Our Case Number: ABP-317679-23

Re: Ringsend to City Centre Core Bus Corridor Scheme.
Ringsend to City Centre, Co. Dublin.

**RE: Observation in Relation to NTA SID Application Ref. 317679
(Ringsend to City Centre Core Bus Corridor Scheme)**

Acting on behalf of Waterside Block 9 Developments Limited, owner of the strategic development site at City Block 9, North Wall Quay, Dublin 1, we wish to make a submission in relation to the National Transport Authority's road development application to An Bord Pleanála for the Ringsend to City Centre Core Bus Corridor Scheme (ABP ref. **317679**).

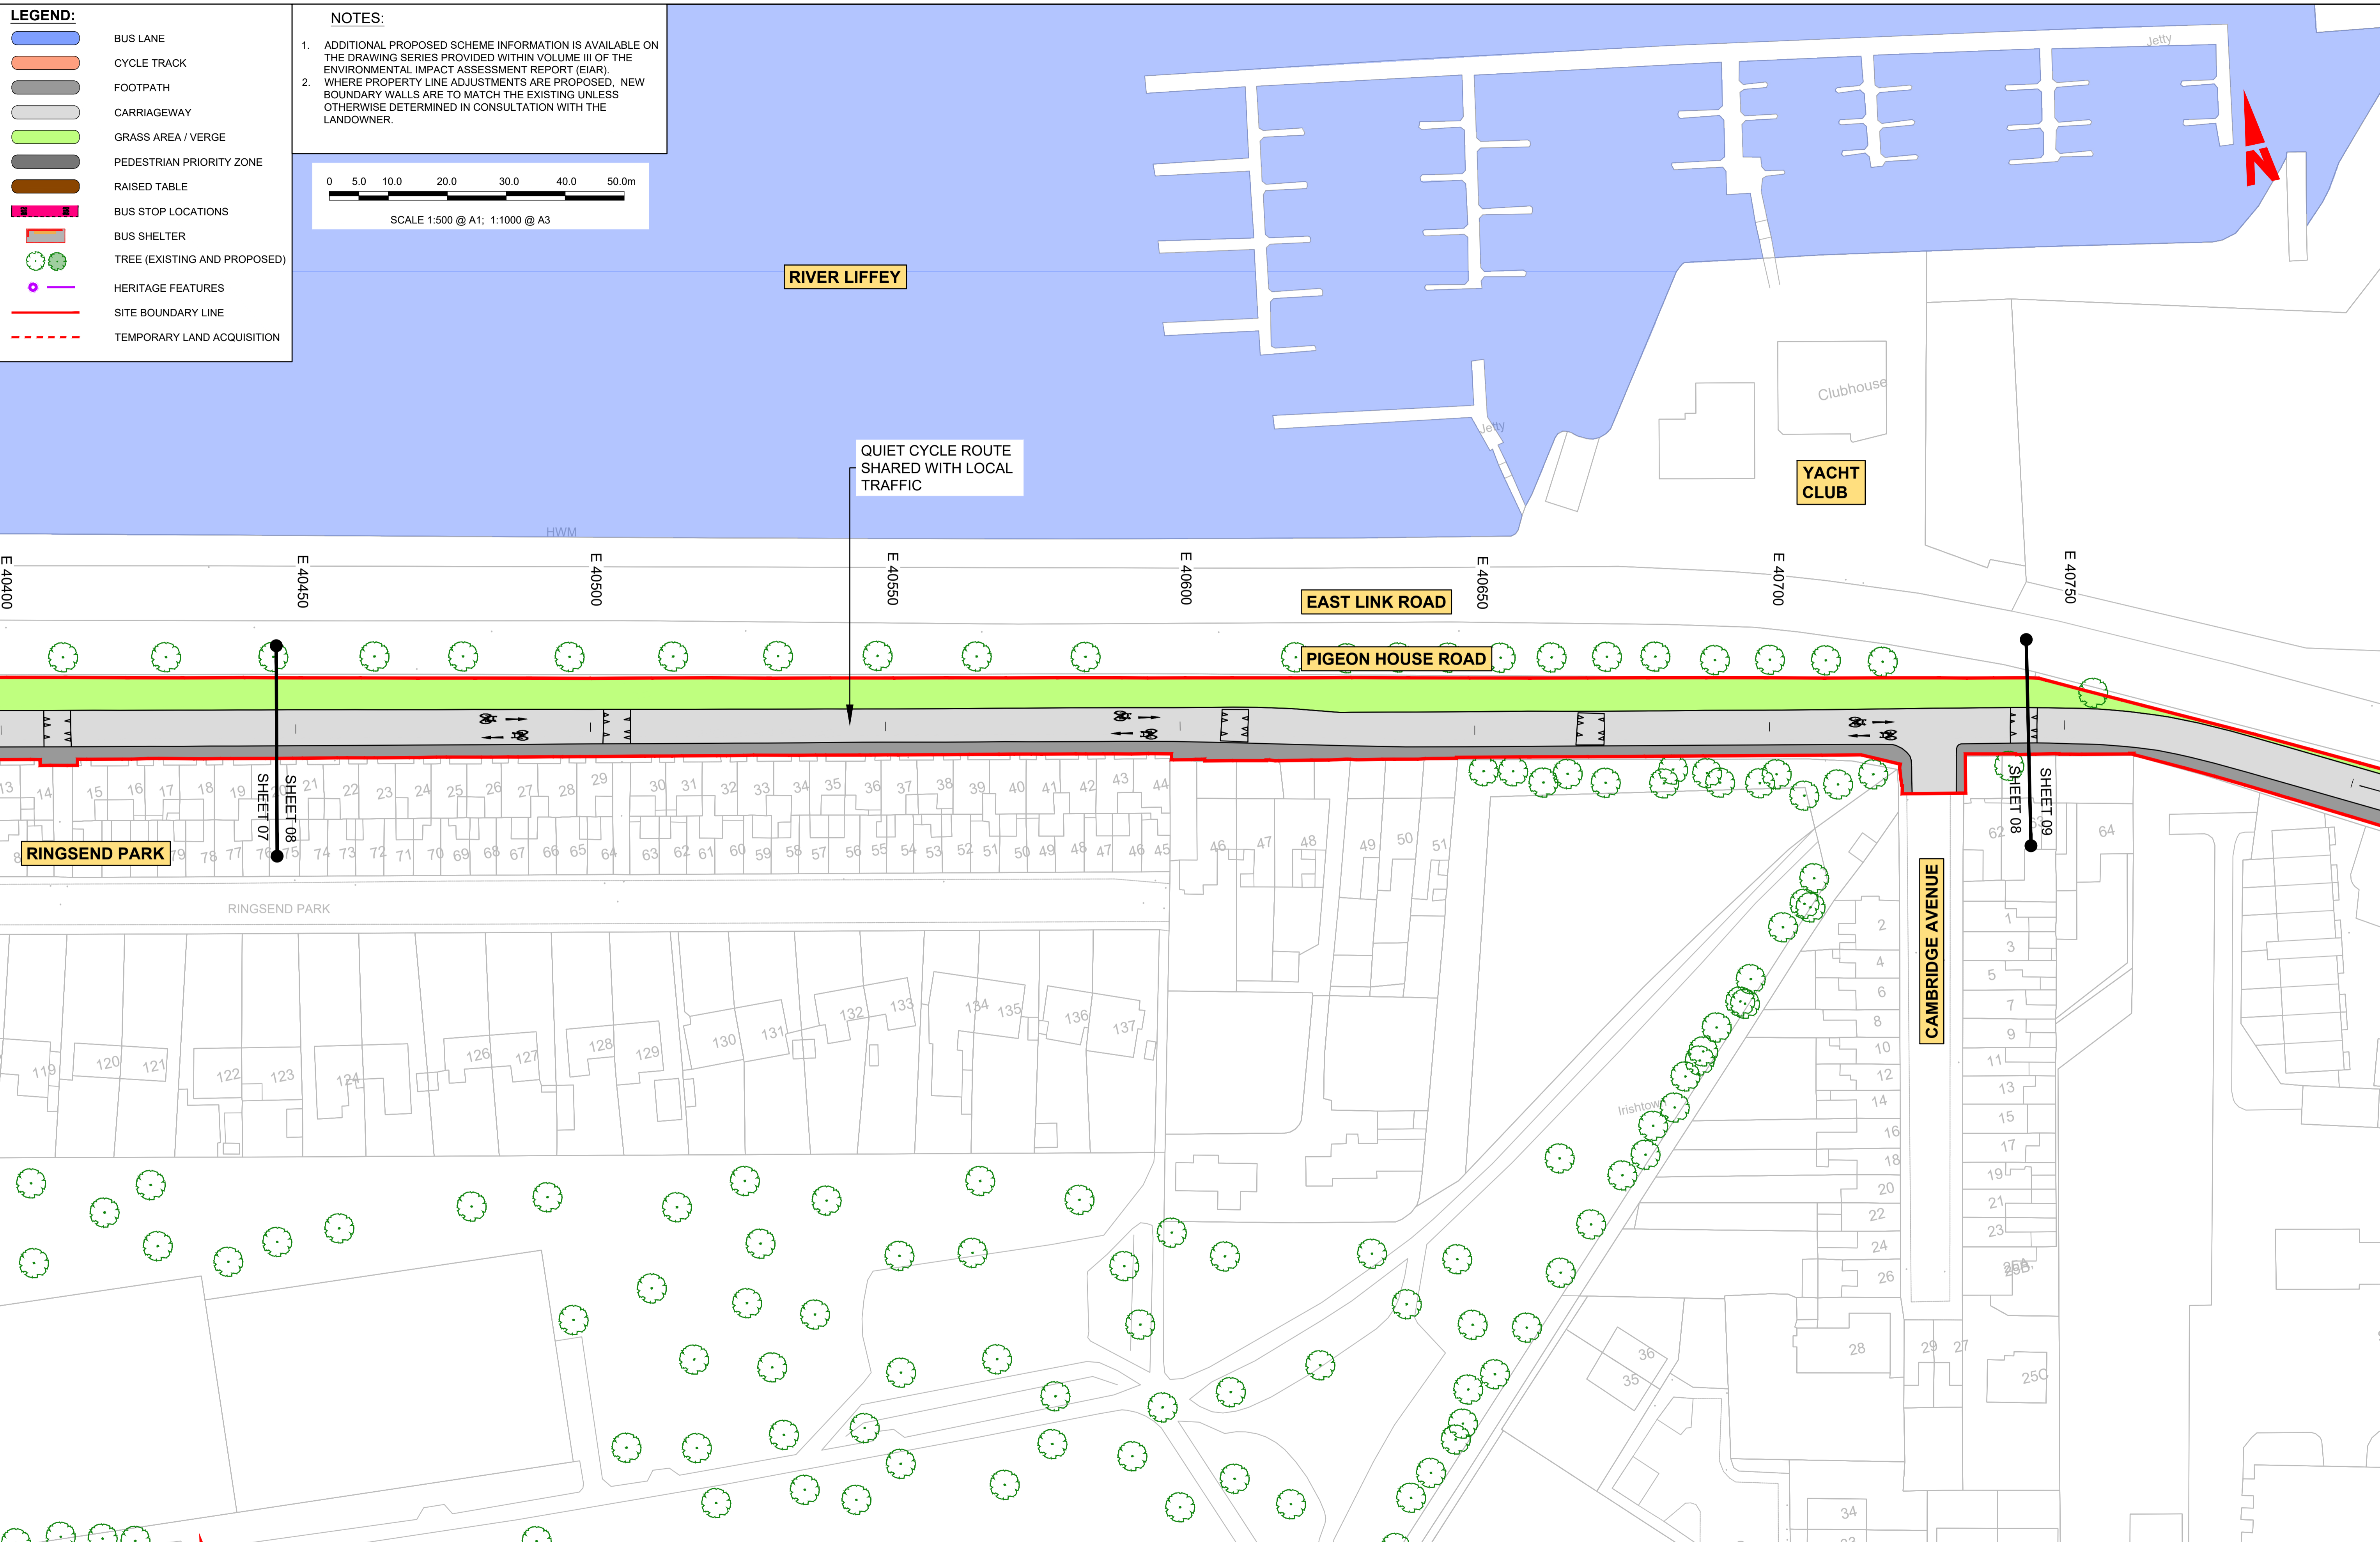
The Ringsend Scheme arrangement drawings (specifically drawing no. **BCIDD-ROT-GEO_GA-0016_XX_00-DR-CR-0004**) show that it is proposed to remove the existing on-street car parking spaces and loading bay on the northern side of North Wall Quay, at the southern boundary of City Block 9. These existing facilities comprise:

- 5no. general car parking spaces
- 2no. disabled-accessible car parking spaces
- 2no. EV charging spaces
- 1no. loading bay

While our client welcomes the implementation of improved public transport infrastructure on North Wall Quay, we are concerned that the removal of the existing disabled-accessible car parking spaces at this location would have a detrimental effect on the accessibility of the City Block 9 site, unless equivalent alternative facilities are provided. We note that the Disabled Access Certificate (DAC) granted for the commercial development now under construction on this site makes reference specifically to these existing on-street disabled-accessible spaces.

We therefore request that any final permission granted for the Ringsend to City Centre Core Bus Corridor Scheme include a condition that at least 2no. replacement disabled-accessible car parking spaces, as well as a general passenger set-down/collection area, be provided adjacent to City Block 9 as part of the scheme, either:

- on North Wall Quay,
- on Castleforbes Road, or
- at the southern end of North Wall Avenue.
